ADC PARKS & GREENSPACE ARBORICULTURE CONSULTATION

PLANNING APPLICATION: AW/87/13/T

ADDRESS: 11 Hechle Wood Aldwick PO21 3TL

① SYCAMORE

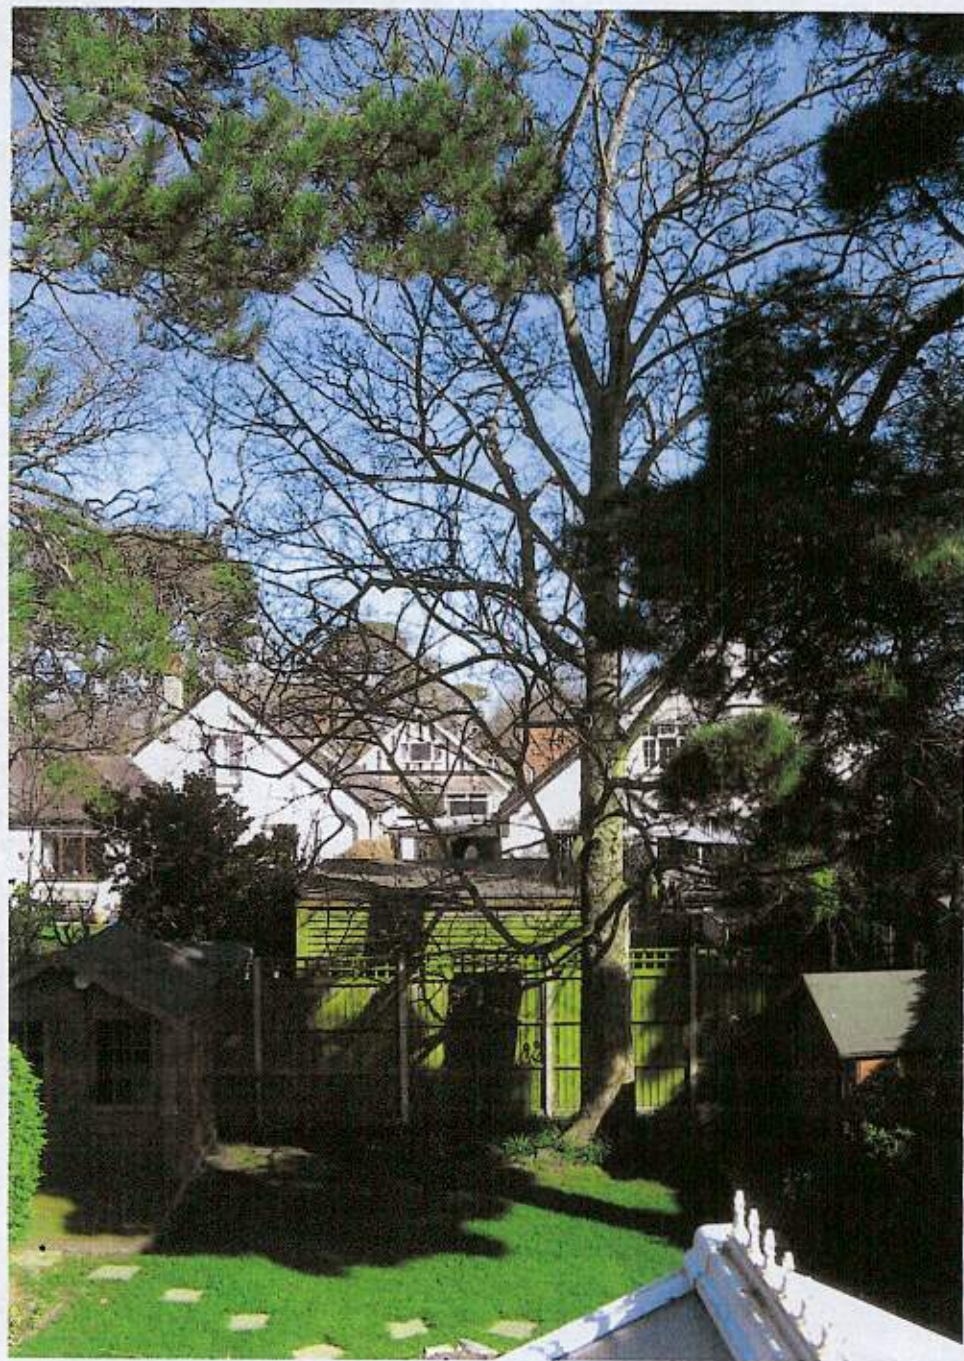
To prevent 'Lion Tailing' the 15% crown thin of the Sycamore should be carried out systematically throughout the tree and not solely to remove epicormic growth from the inner crown core.

② T448 - southern side

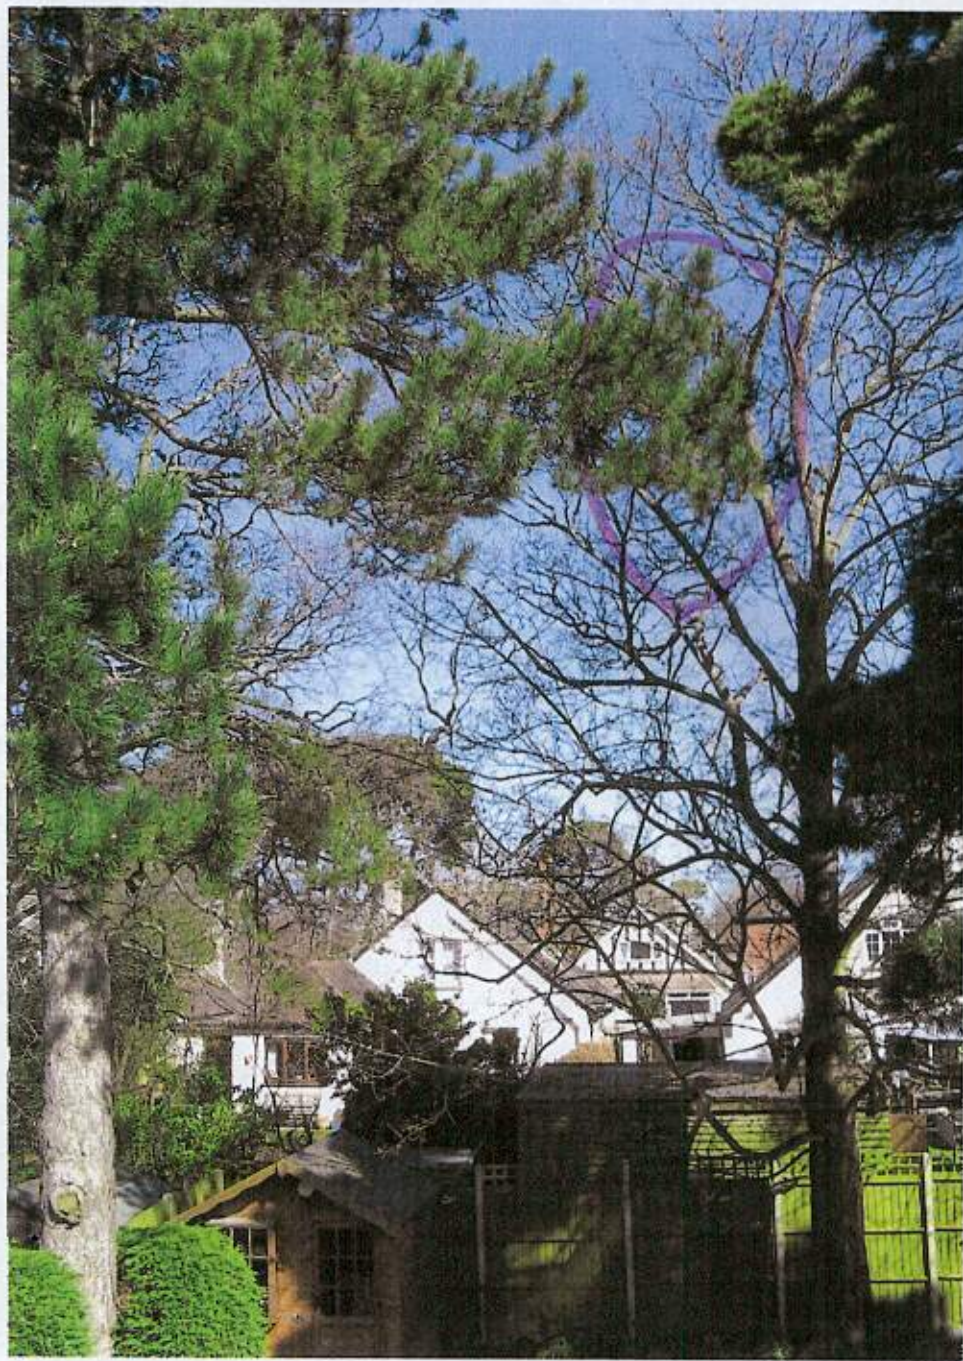
RECOMMENDATION: Remove small internal branches to 1No. Sycamore and dead wood and epicormic growth not to exceed 15% thinning. Works to be completed when tree in full leaf. Shorten lower branch (bowing) southern side by 2 metres to appropriate growing point and shorten lower branch east side by 1 metre to appropriate growing point to 1No. Corsican Pine.
